**KIRKLEES METROPOLITAN COUNCIL  
INVESTMENT & REGENERATION SERVICE**

**DELEGATED DECISION TO DETERMINE PLANNING APPLICATIONS**

Reference No:	<b>2026/62/90432/W</b>
Site Address:	19, Ellison Street, Crosland Moor, Huddersfield, HD4 5DS
Description:	Erection of side and rear extensions
Recommending Officer:	Joshua Merriman

## **Officer Report – 2026/90432**

DATE	23.10.2025	SCALES	AS SHOWN @ A1.	DRAWING NUMBER	REVISION
DRAWN	M.A	CHECKED	M.A	APPROVED	PAD.220.268

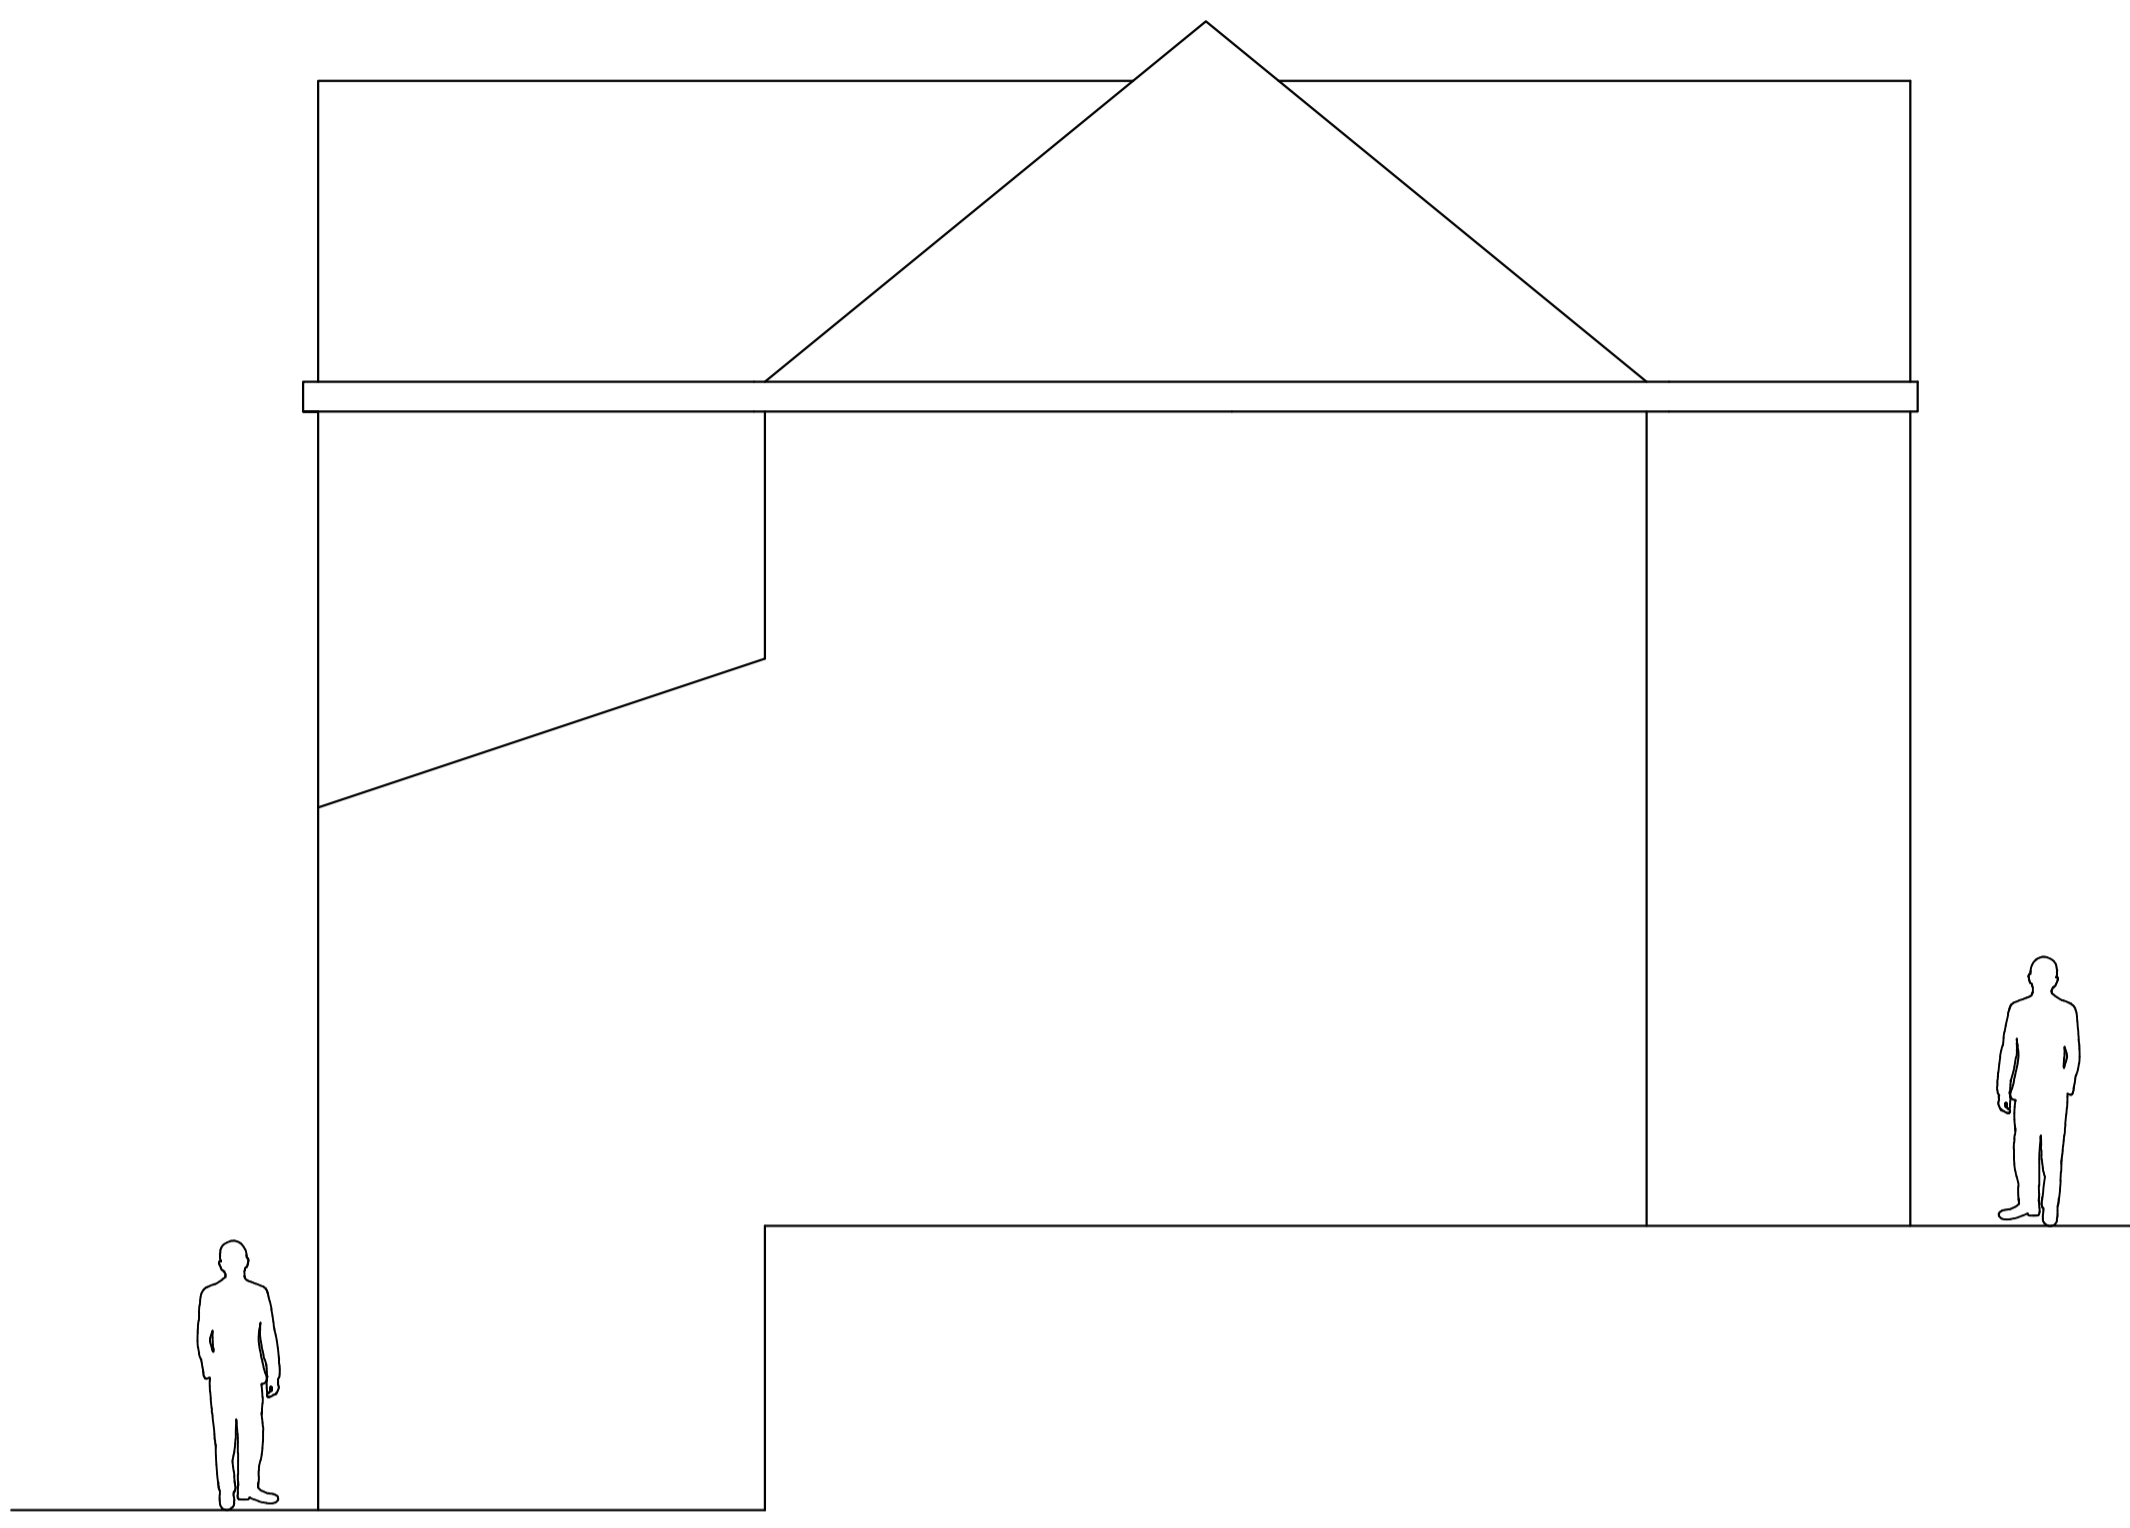
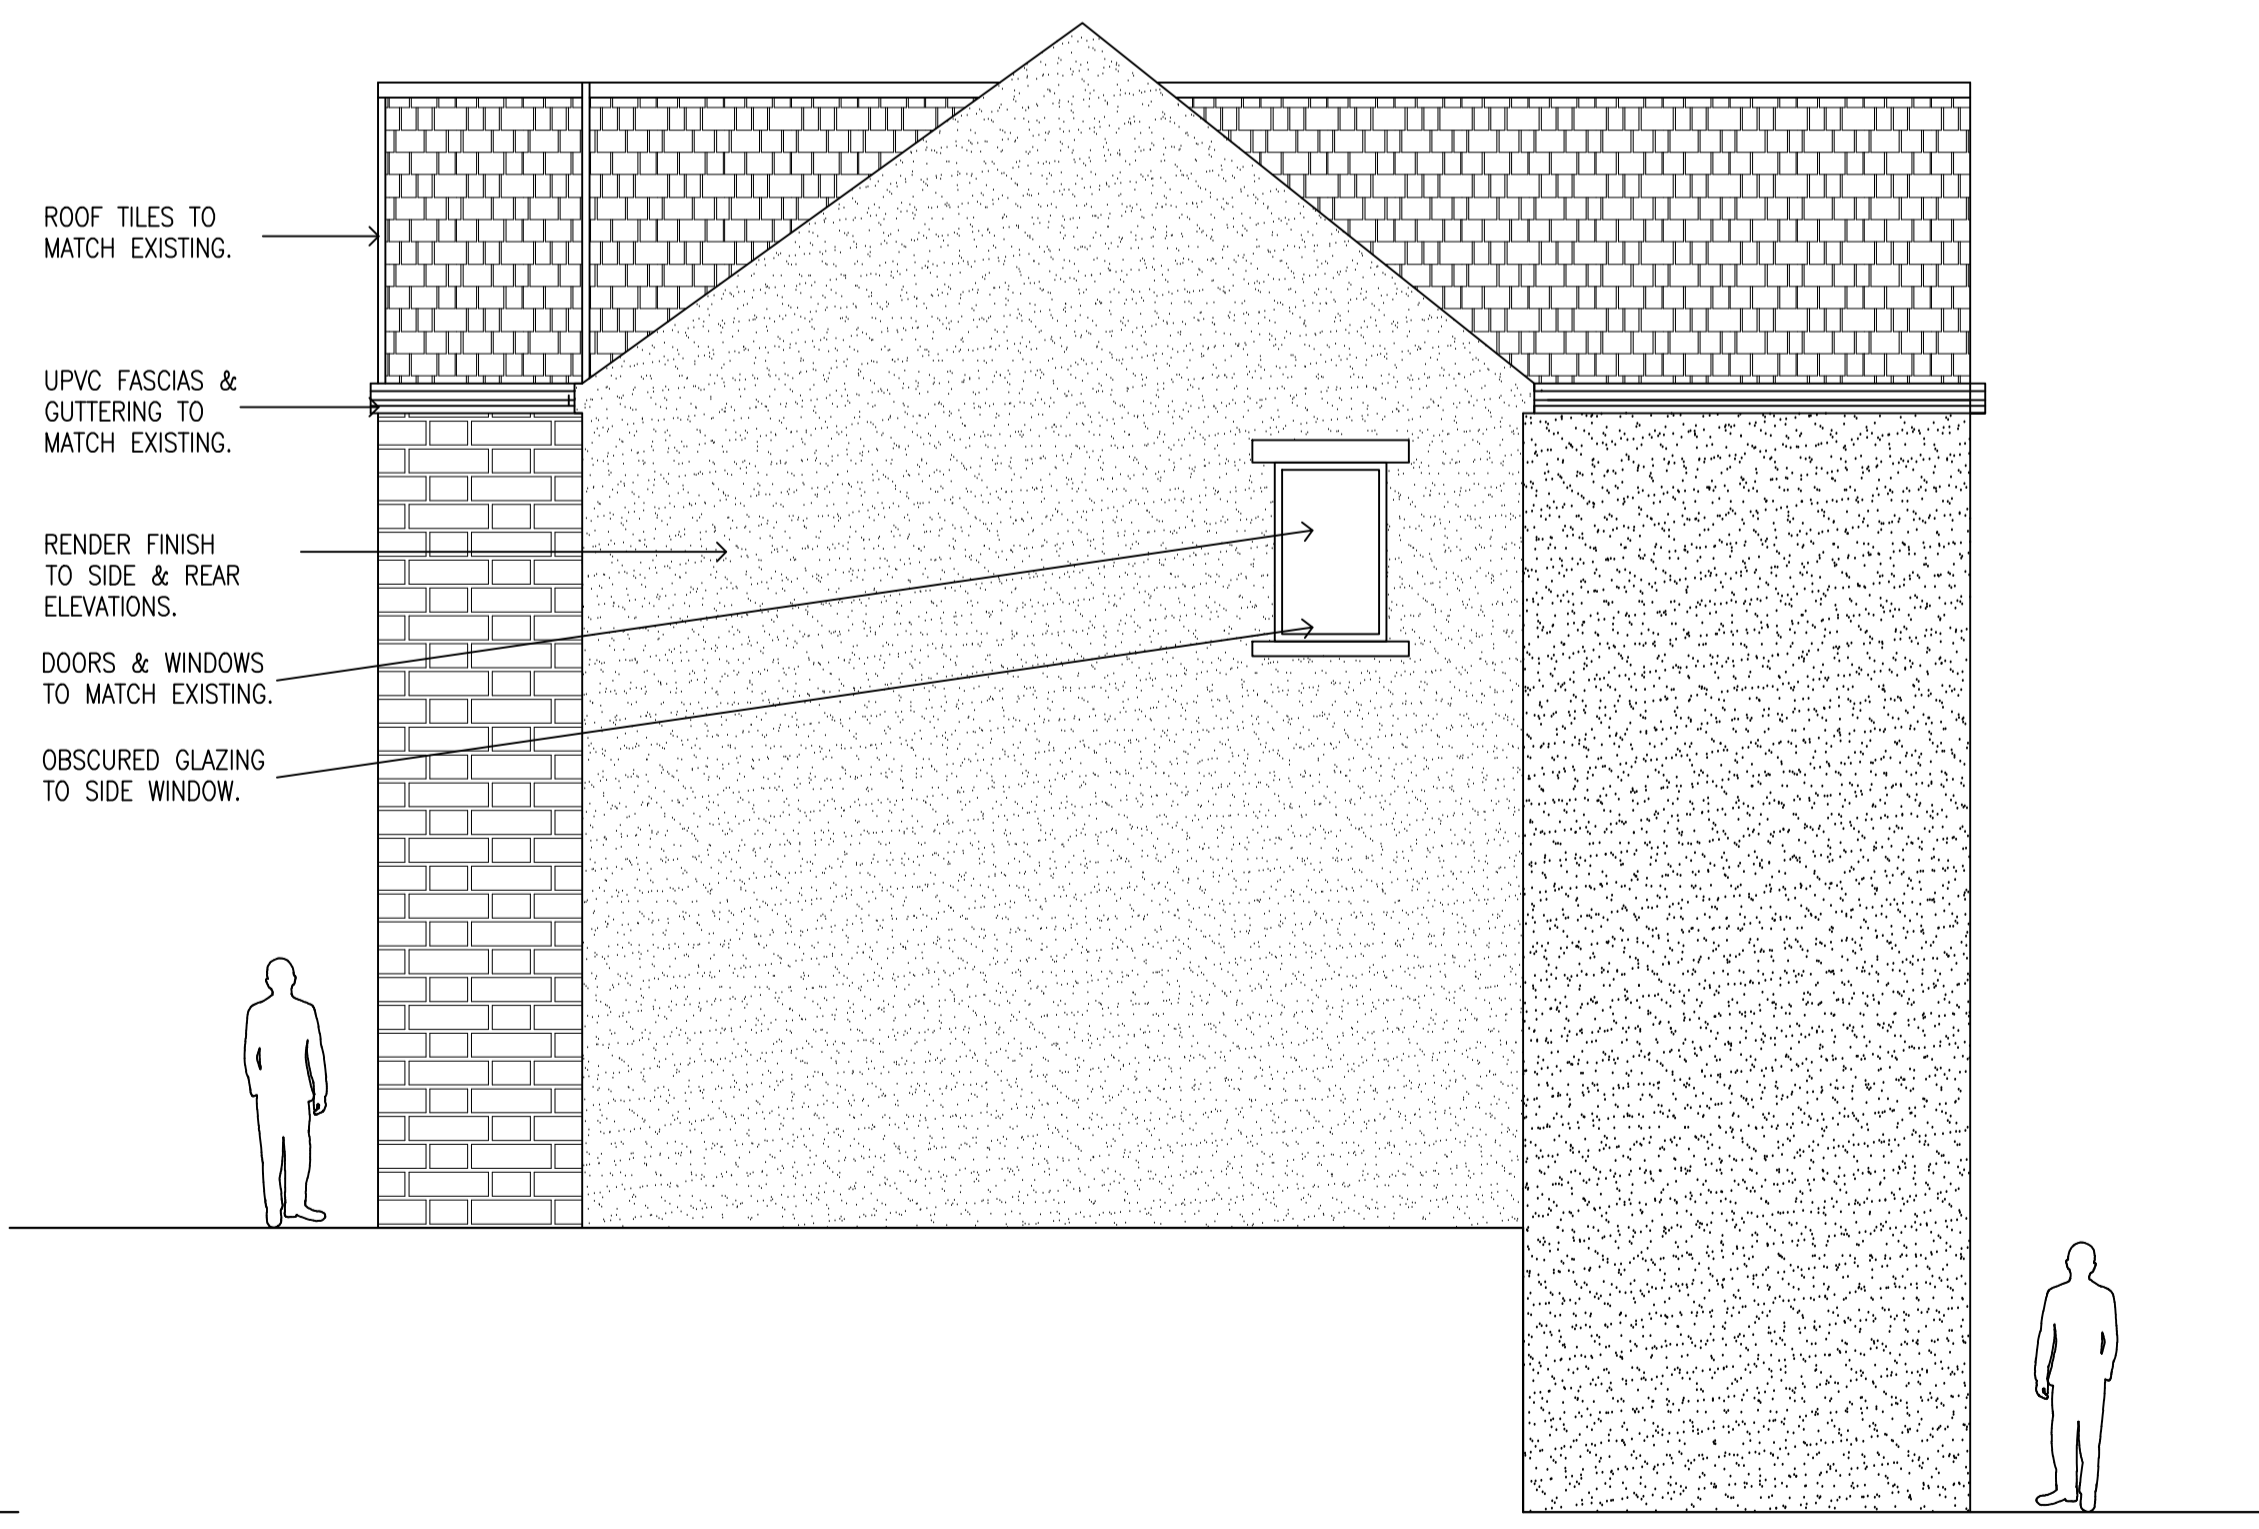
Given the contemporary style of the proposed extensions, using glass facades, breeze block, and render rather than stone and pebbledash to match the existing building, it is considered that the proposed frontage of the property, and two storey side extension would appear unsympathetic to the host property or the surrounding street scene, which is characterised by traditional properties, most of which are bungalows.

Furthermore, by virtue of these contemporary extensions, the additions to the application property would result in unbalancing a pair of semi-detached properties, with the application property and adjoined dwelling appearing different in character and appearance, thus negatively impacting the surrounding street scene.

The proposal will involve the installation of floor to ceiling windows to the front elevation on the proposed side extension and also on the existing gable projection. This will see an expansive area of glazing to the front elevation. These windows also appear to have the ability to fully open, being bi-folding. Whilst there is existing fenestration on the front elevation at present, this will see an increased amount of glazing. However, the distance between the properties is such that any adverse issues will be insignificant to that which currently exists and is considered on balance to be acceptable in this instance.

1. The proposed development, by reason of its form, massing, materials and architectural detailing, would appear visually incongruous and unsympathetic to the host property and the established character of Ellison Street, whilst also disrupting the visual coherence of the semi-detached pair of properties, resulting in an unbalanced relationship that would be harmful to the appearance of the street scene and fail to comply with Policies LP1, LP2, and LP24 of the Kirklees Local Plan and Policies within Chapters 2 and 12 of the National Planning Policy Framework.
